Engineers Comments Regarding Condition 5- Surface Water Drainage

APPLICATION NO: M/50/19/DOC

Site Address: Fidra Yapton Road Middleton-On-Sea PO22 6DX

Description of Works: Approval of details reserved by condition imposed under M/9/19/HH relating to condition 5-surface water drainage.

extending homes Tel:- 01243 555208 enquiries@extendinghomes.co.uk	
TITLE:-	Soakaway Details for 'Fidra' Yapton Road Middleton West Sussex PO22 6DX
DATE:-	24th May 2019
SCALE:-	Drainage Details Scale 1:100 on A2
DRAWN:-	P.Robinson
DWG. No. 1905241/PL/3

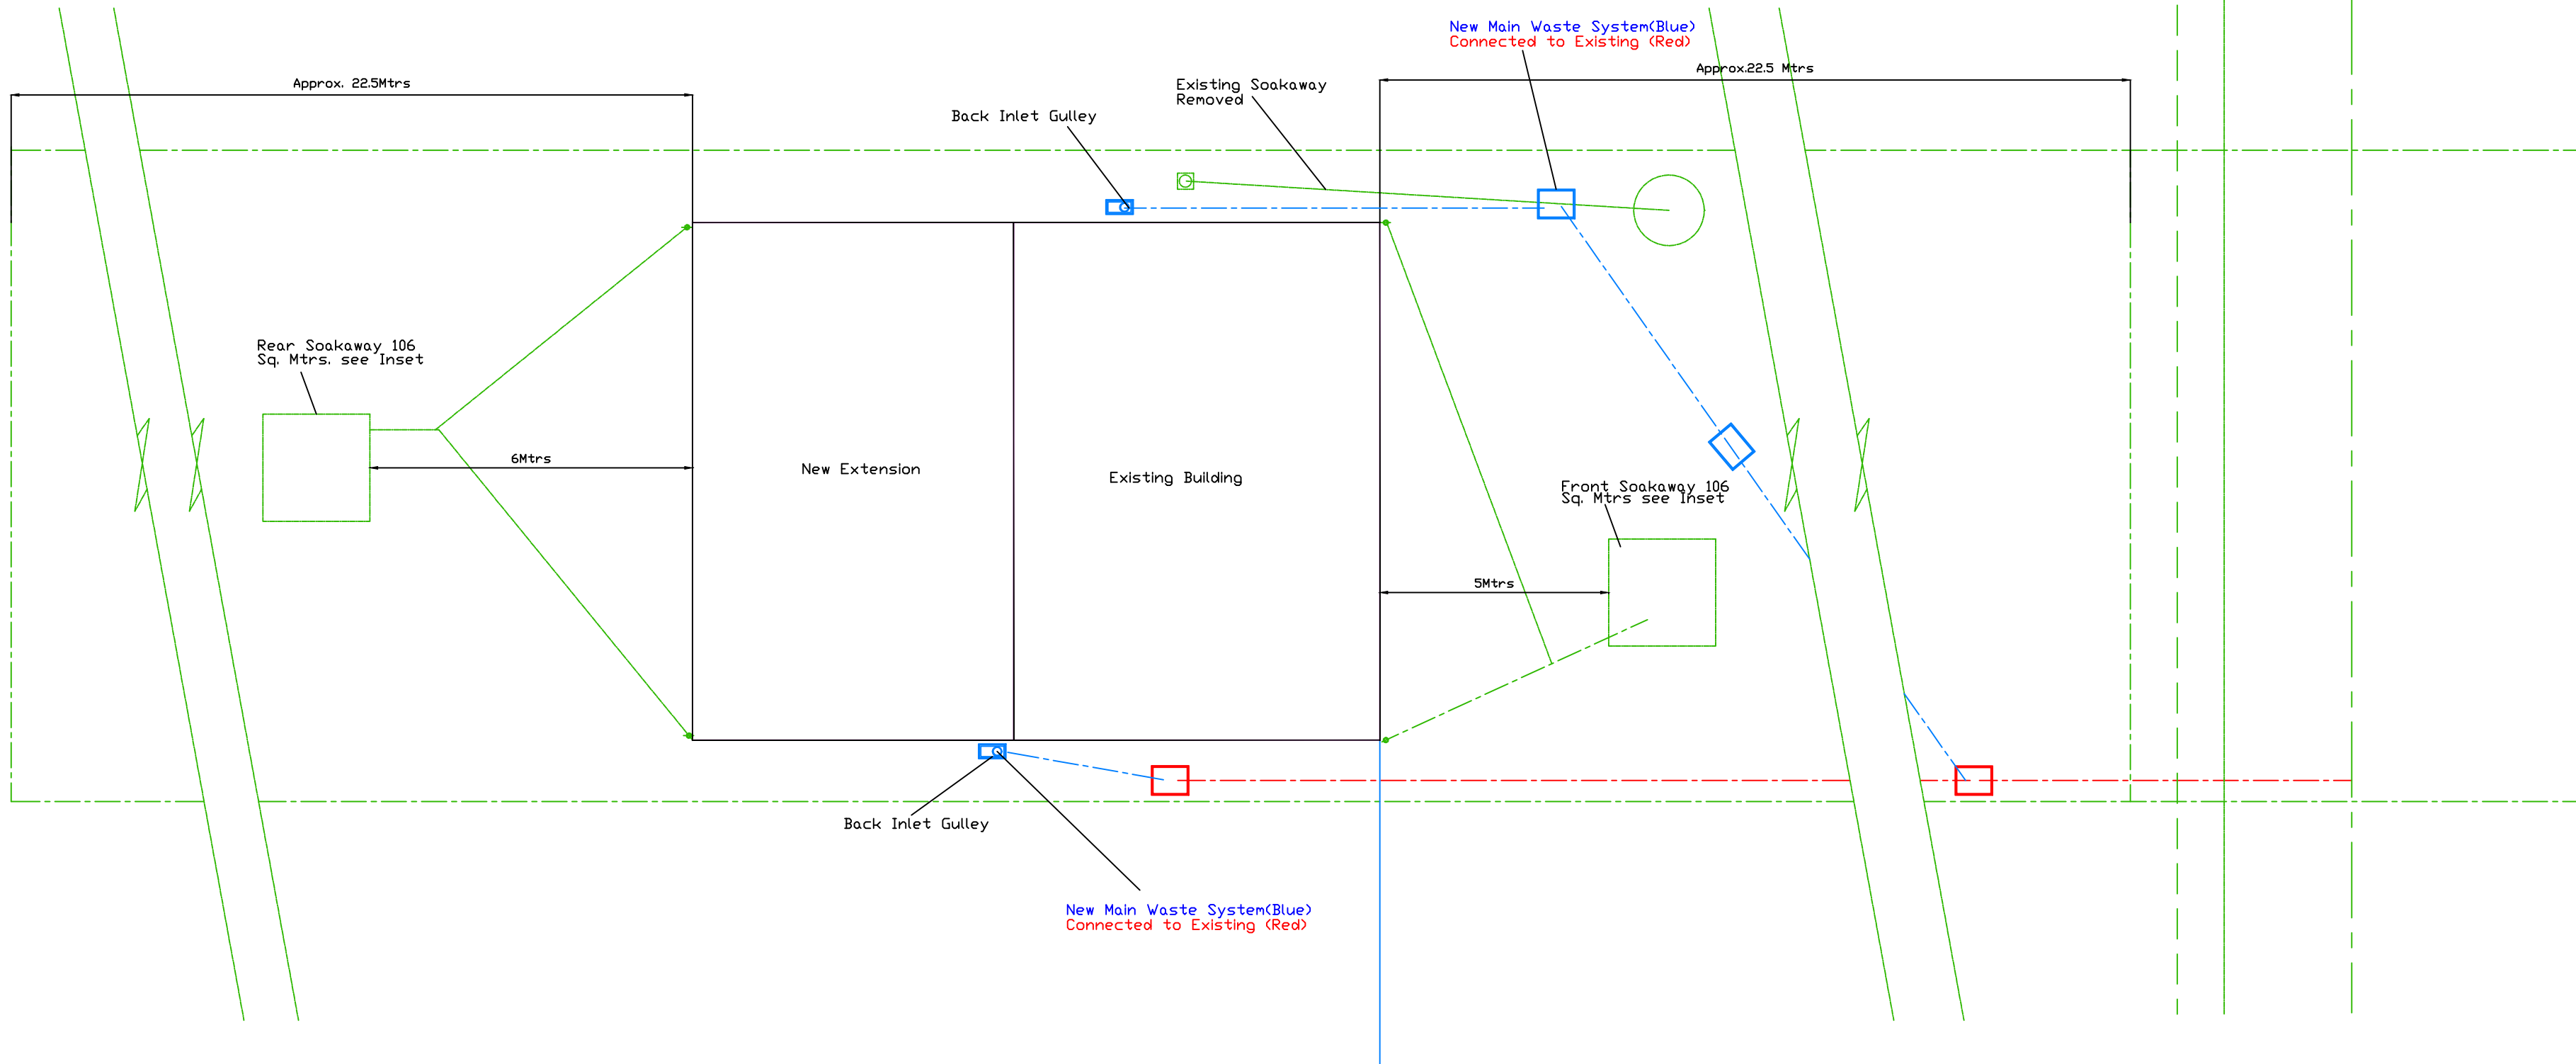
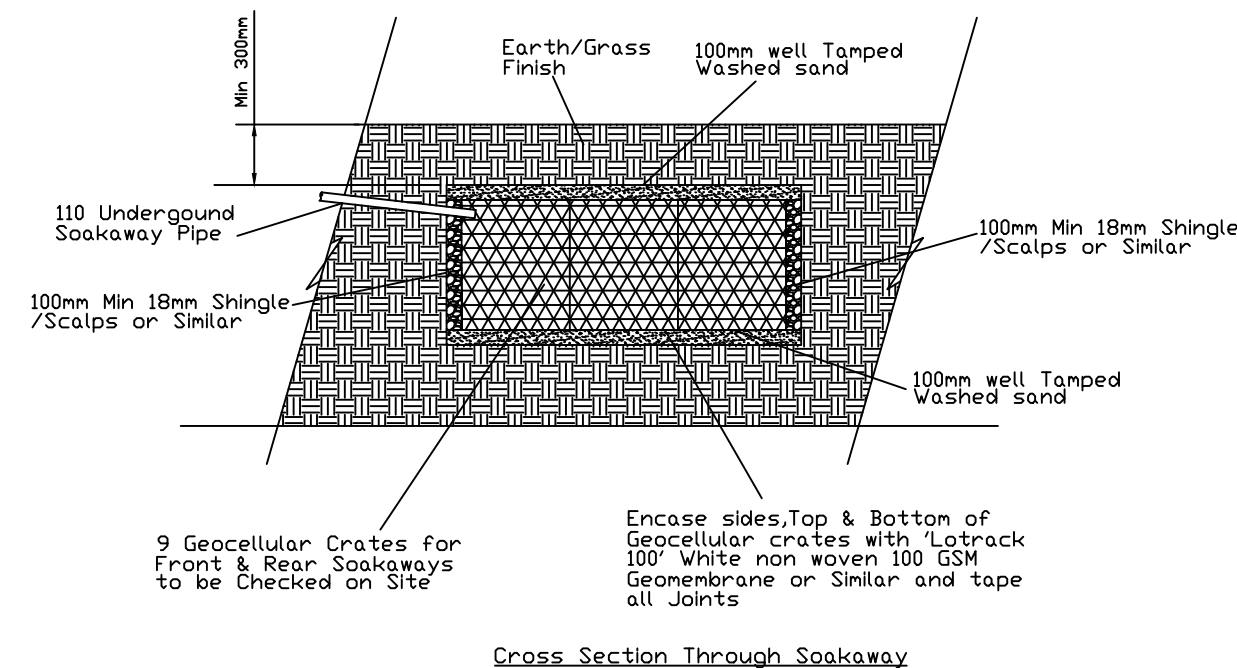
1. No winter groundwater monitoring results have been supplied. These must be provided.
2. Winter infiltration testing results need to be submitted.
3. Please can the applicant provide calculations in support of their design.
4. Invert and cover levels need to be detailed on plan.
5. Silt traps must be provided upstream of all connections to soakaways.
6. Further construction detail drawings are required.
